Final Drainage Report

Winsome Subdivision Filing No. 3 El Paso County, Colorado

PCD File No. SF-22-009

Prepared: February 2, 2023

WINSOME FILING NO. 3

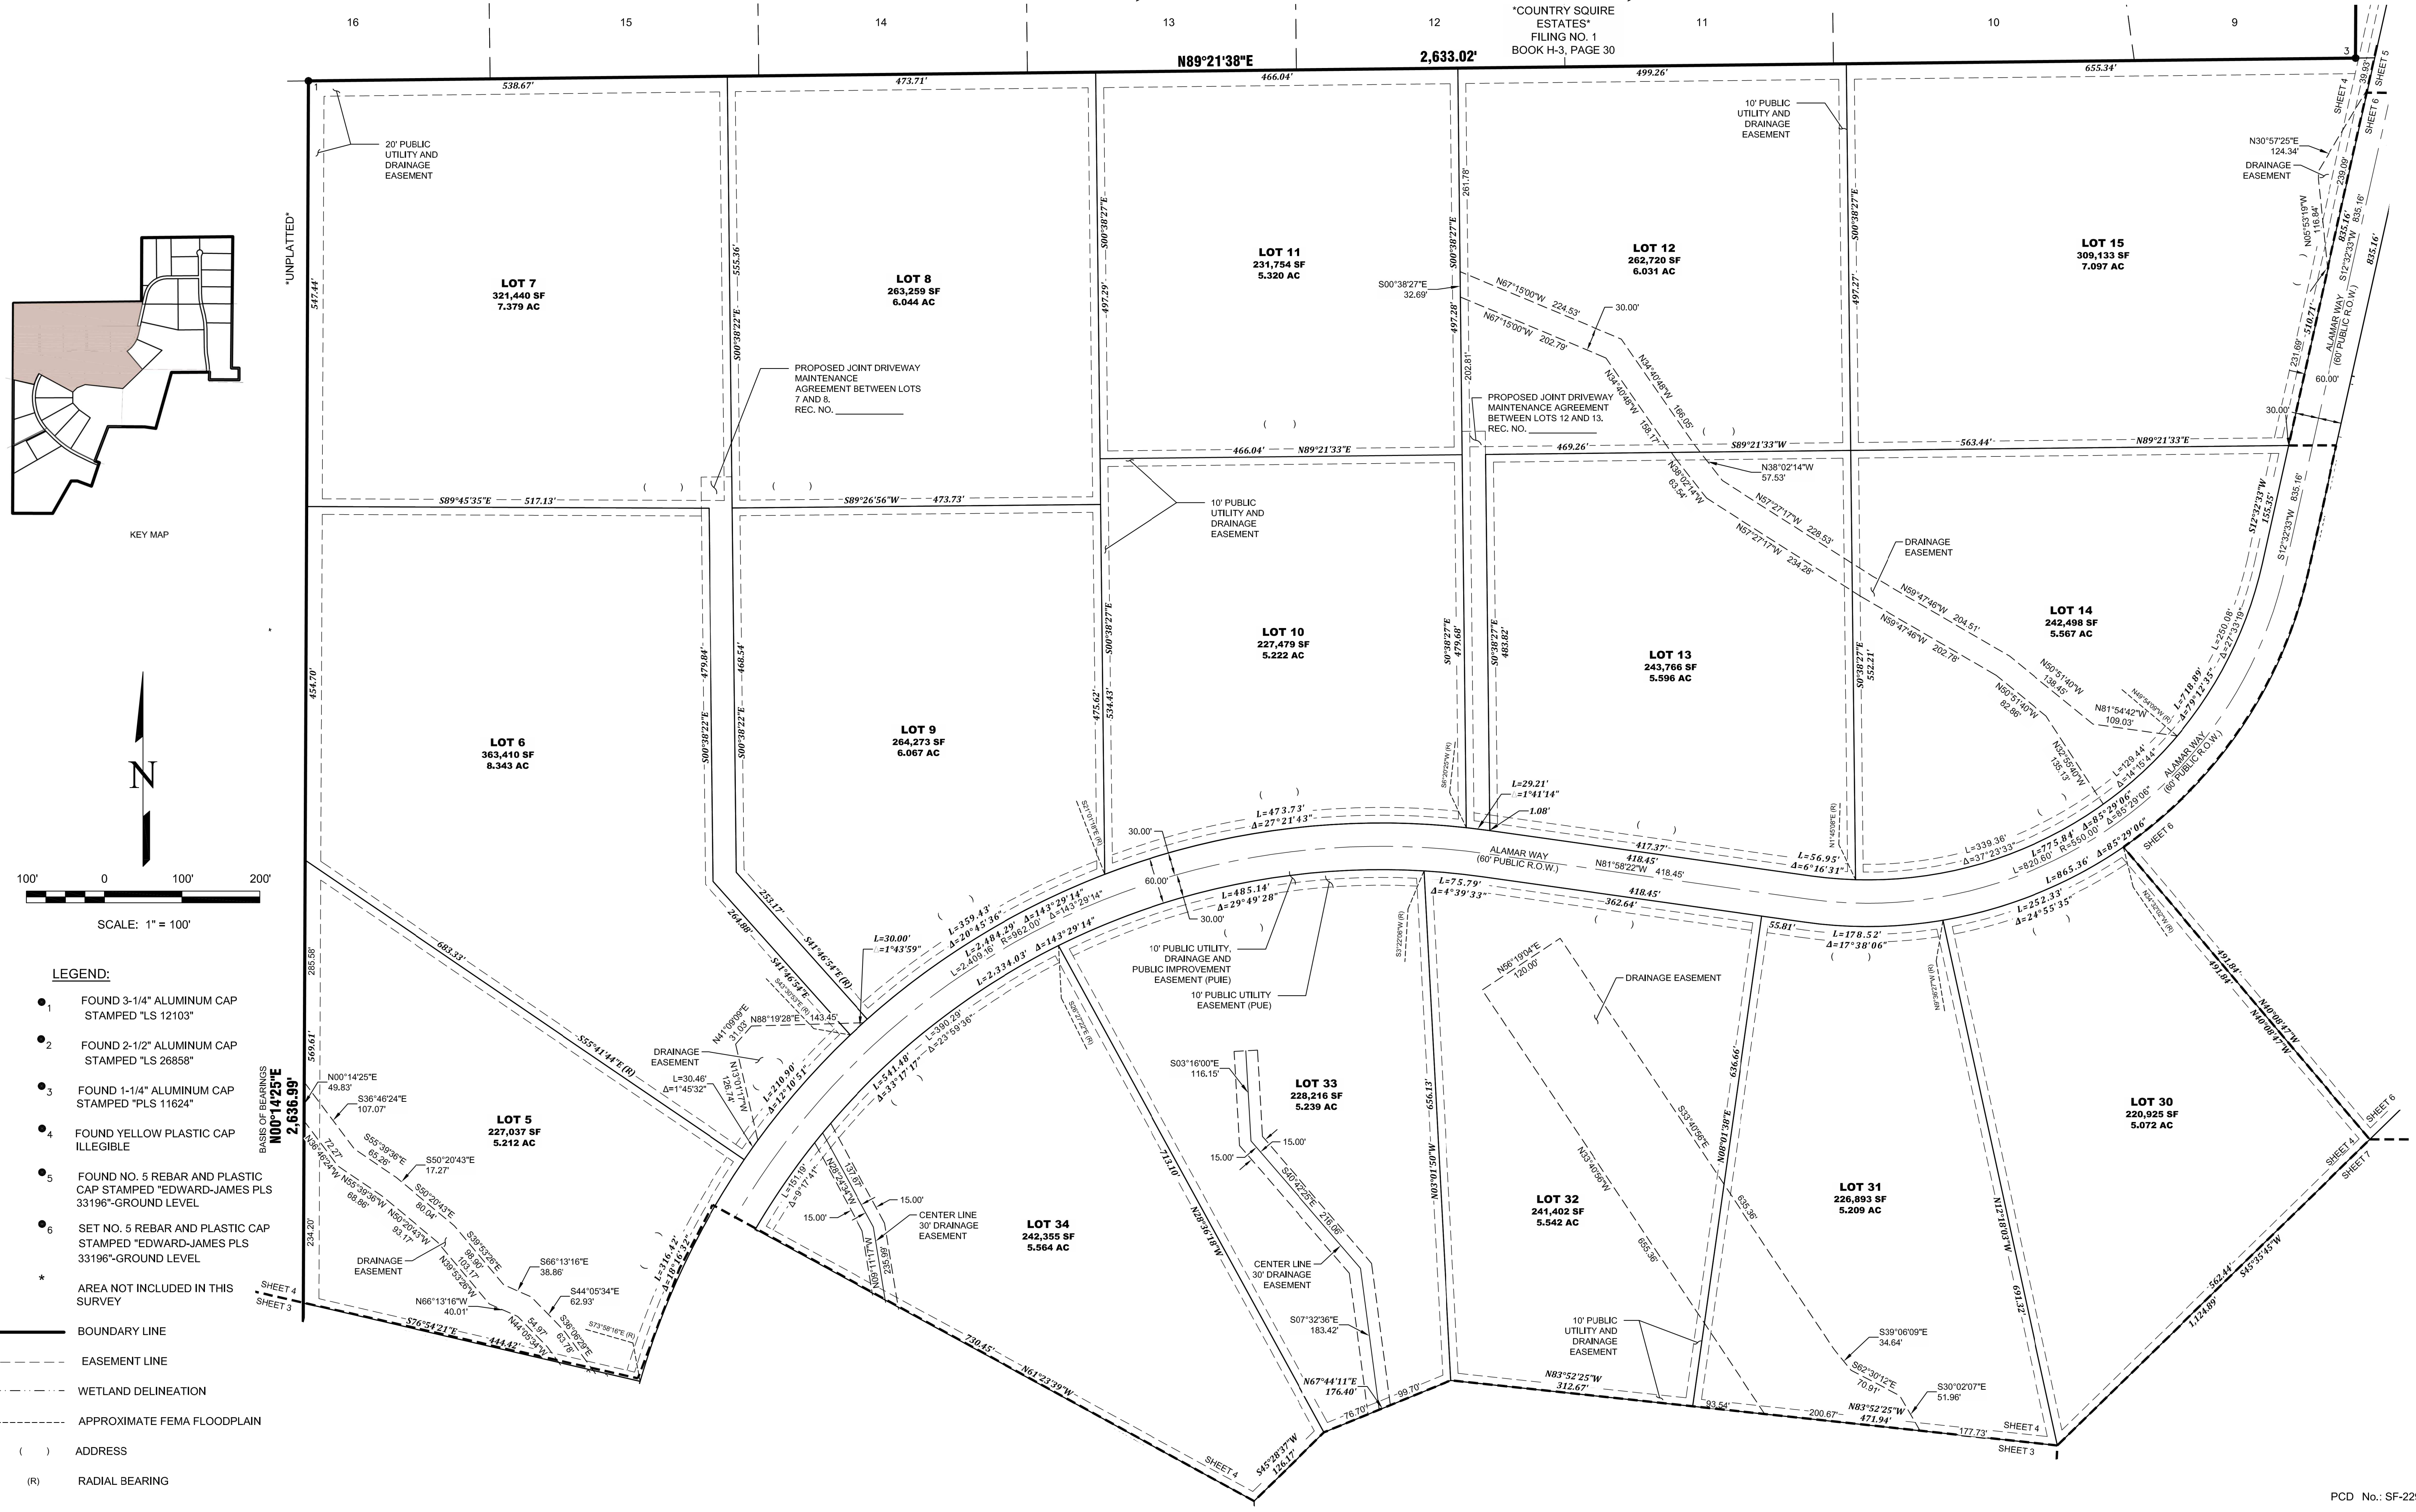
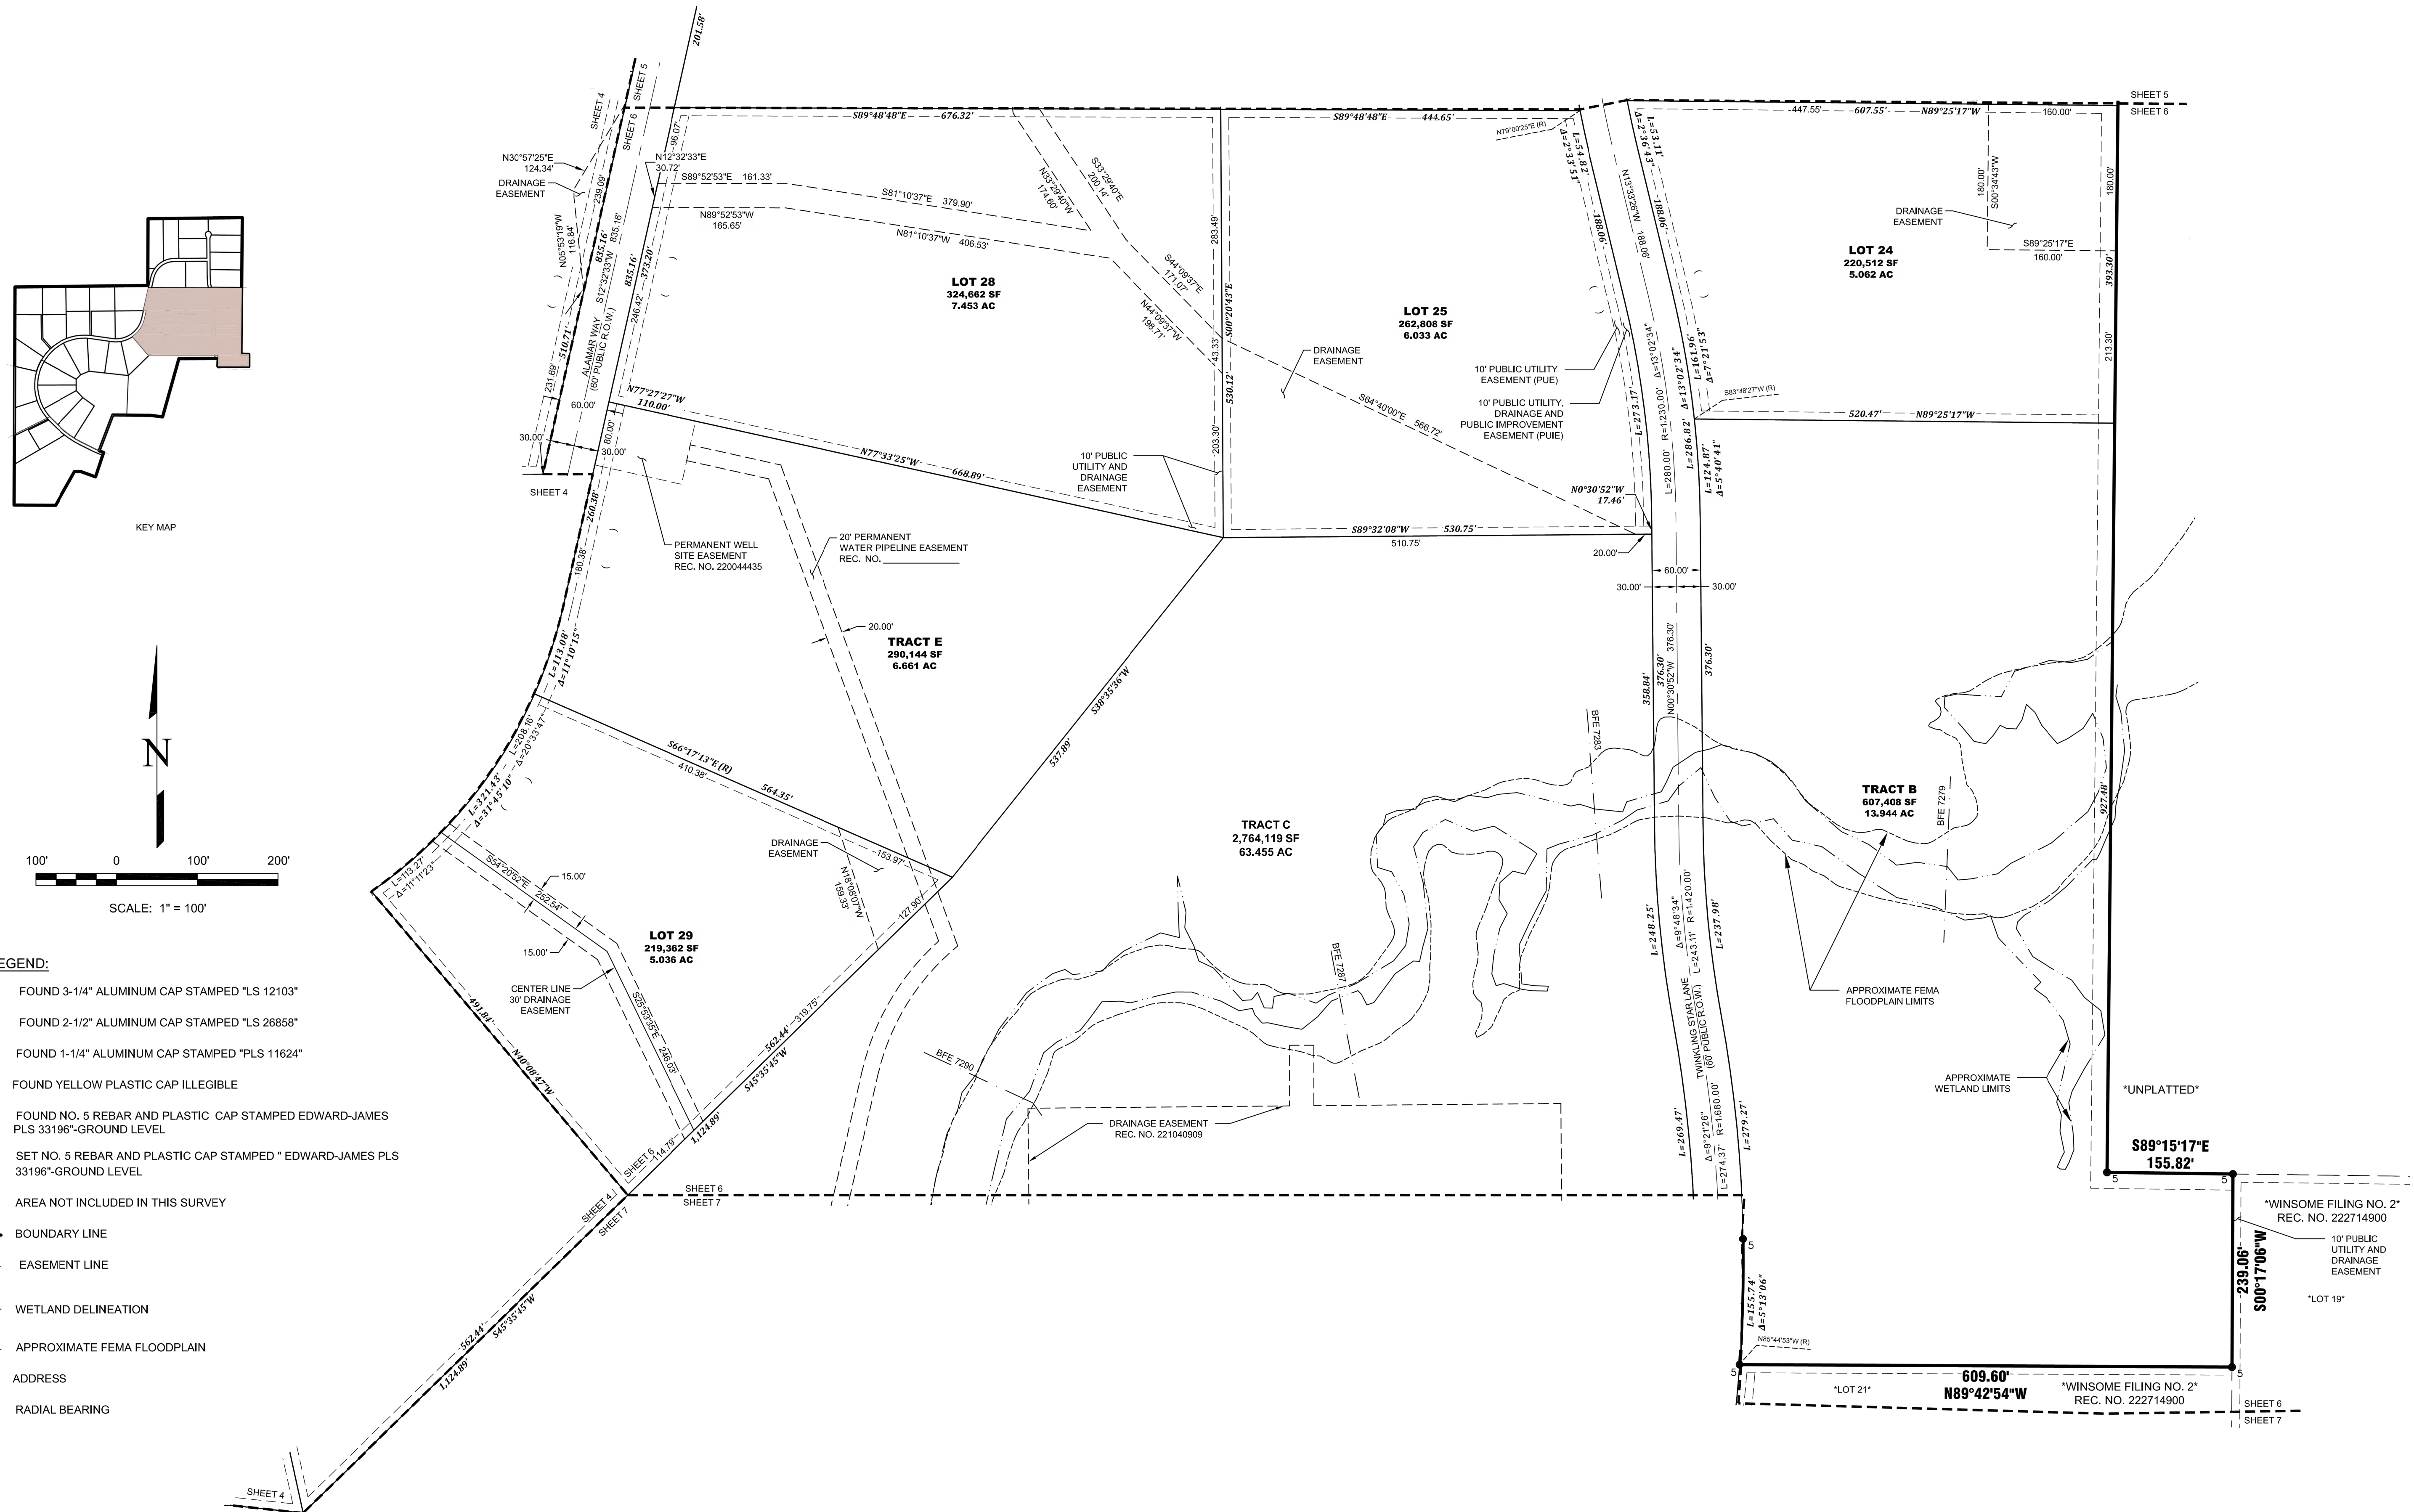
BFE's and floodplain extents from the CWCB risk map program accepted by FEMA to be shown on plat. contact Keith Curtis for approved BFE and floodplain extents shapefiles,
"Roadway improvement across the creek" per note 7, require either a less than 6" rise certification per FEMA guidance, or an approved CLOMR from FEMA prior to requesting a local floodplain permit for this work .
